RECOMMENDATION FOR PLANNING AND DEVELOPMENT COMMITTEE

APPLICATION REF: 3/2026/0230

THE ERECTION OF 60 DWELLINGS COMPRISING HOUSES, BUNGALOWS AND FLATS, RELATED INFRASTRUCTURE (INCLUDING PUBLIC OPEN SPACE) AND LANDSCAPING AT LAND TO THE SOUTH OF RIBBLESDALE PRIMARY SCHOOL WEST AND NORTH OF HIGHER STANDEN DRIVE, CLITHEROE.

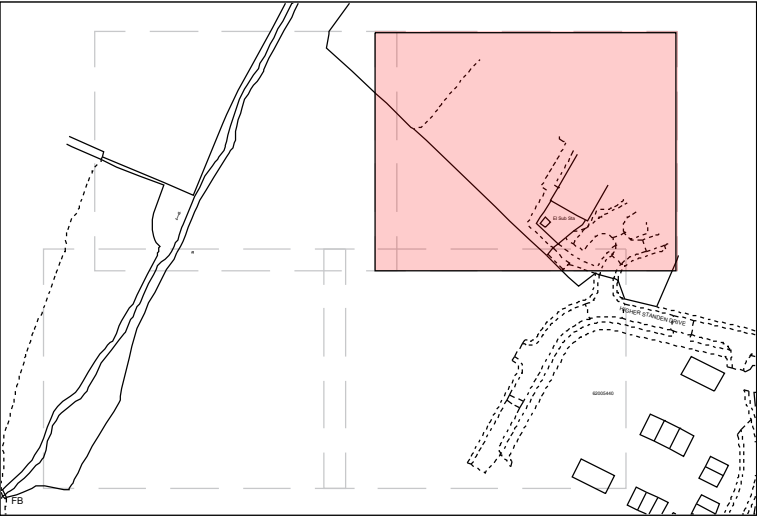
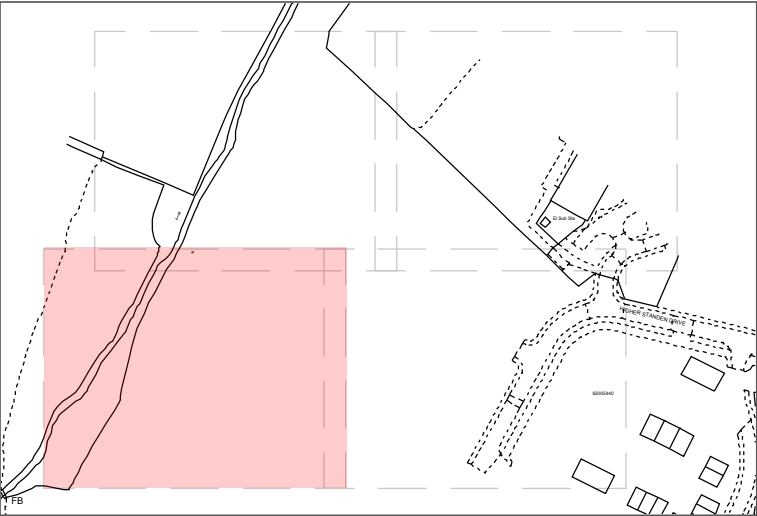
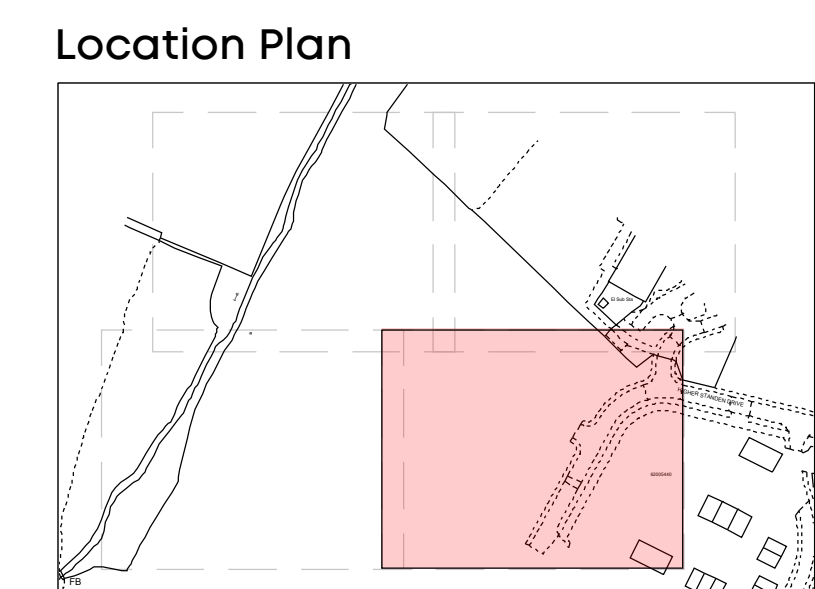
I am not entirely convinced that some of the claimed on-site gains in biodiversity will be able to be effectively achieved; in particular, the area of specie-rich neutral grassland proposed has also been identified as an area for new tree planting in updated landscaping plans. If tree density exceeds more than 10% of the grassland area, the grassland may be compromised. In addition, if this area is also to be used as public open space the grass land diversity could also be compromised by public access. Nevertheless, biodiversity gains could still be achieved by increasing the number of off-site units purchased even if the neutral grassland is not capable of achieving the required condition.

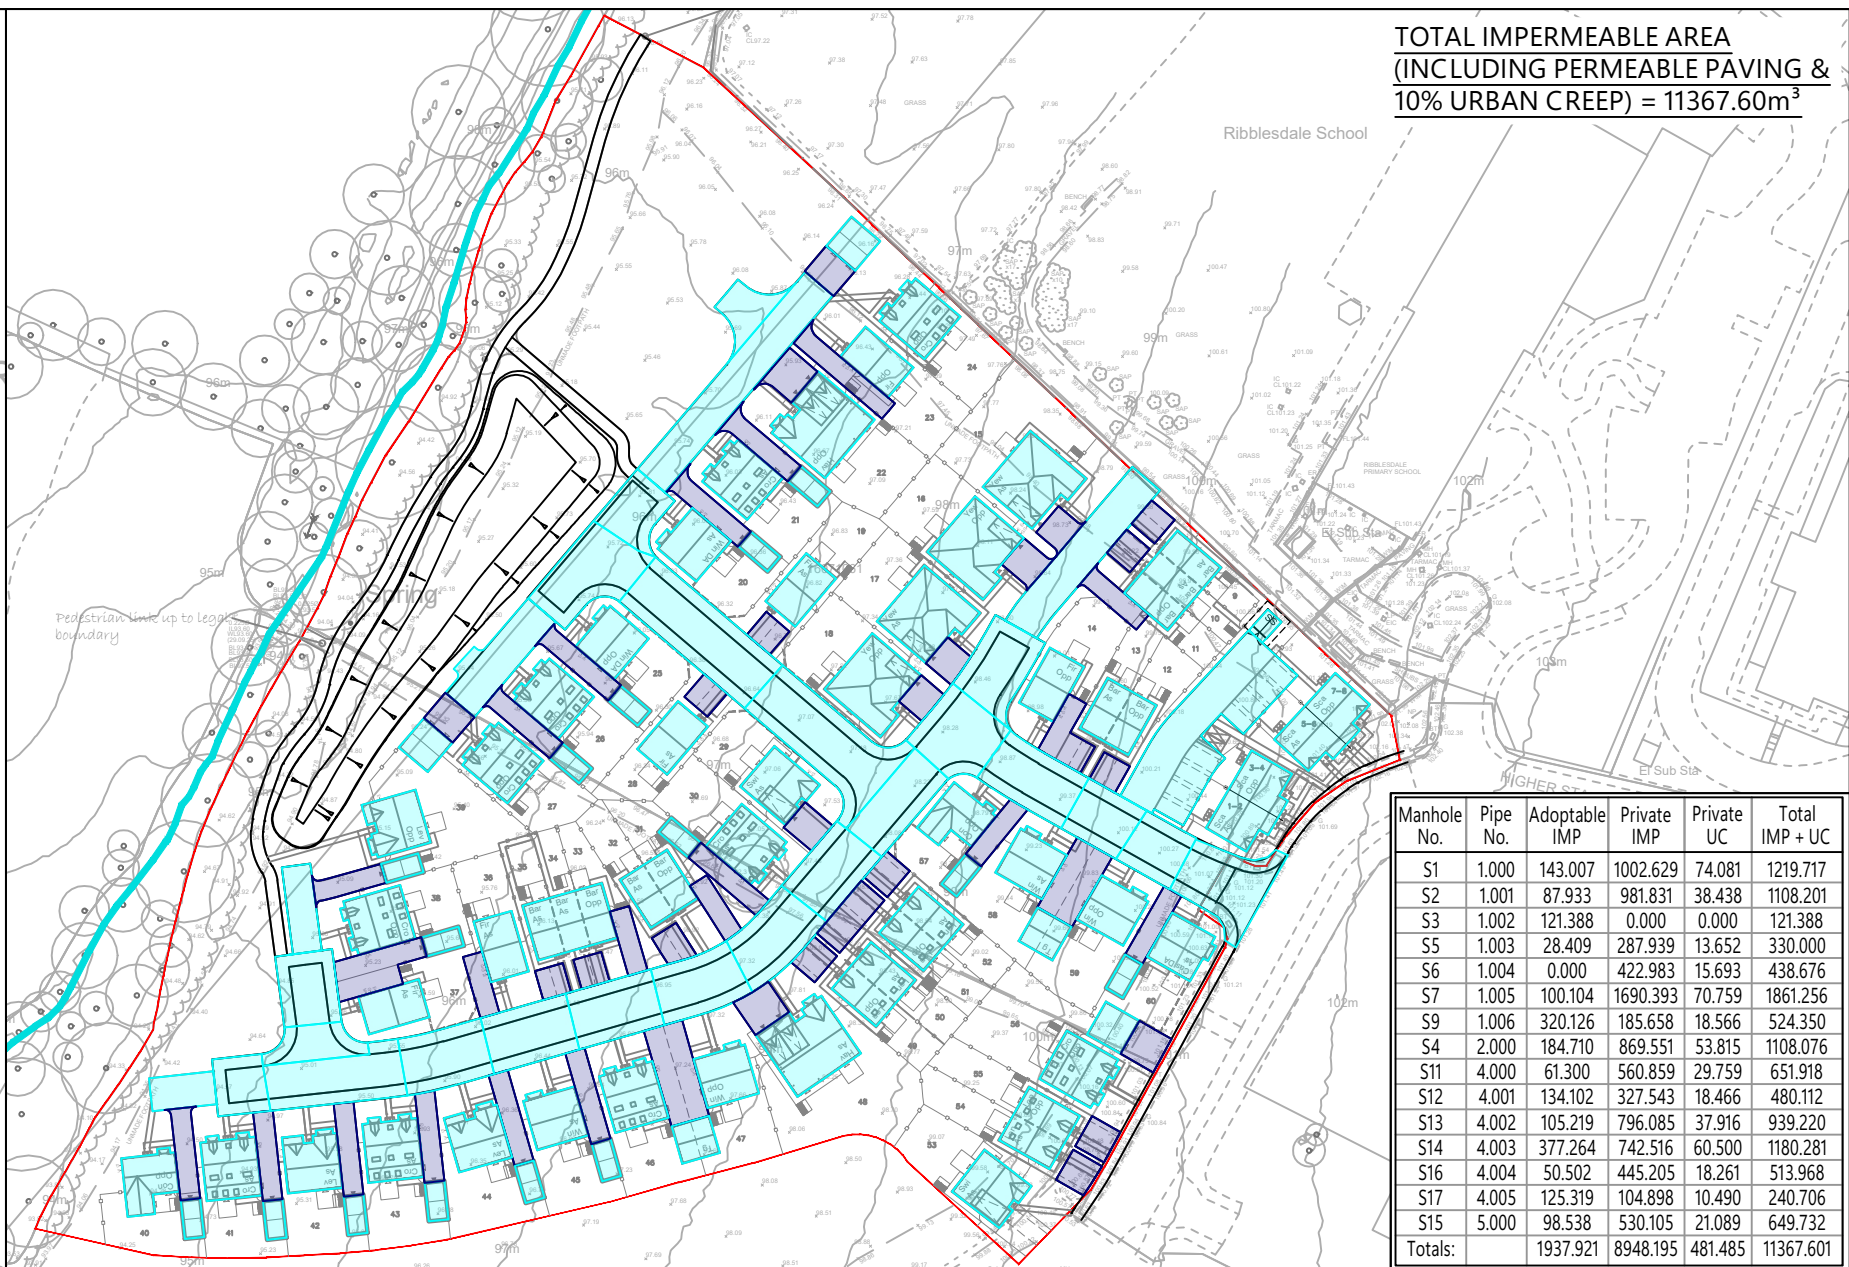
Following review of the submitted Drainage Strategy we can confirm that whilst the strategy is acceptable in principle there are elements that might not be acceptable and require resolution.

The foul connection point is to an unchartered/private sewer – confirmation is required as to where this discharges to the known network.

Recommend this concern is addressed prior to approving the drainage strategy or a condition attached to any grant of permission.
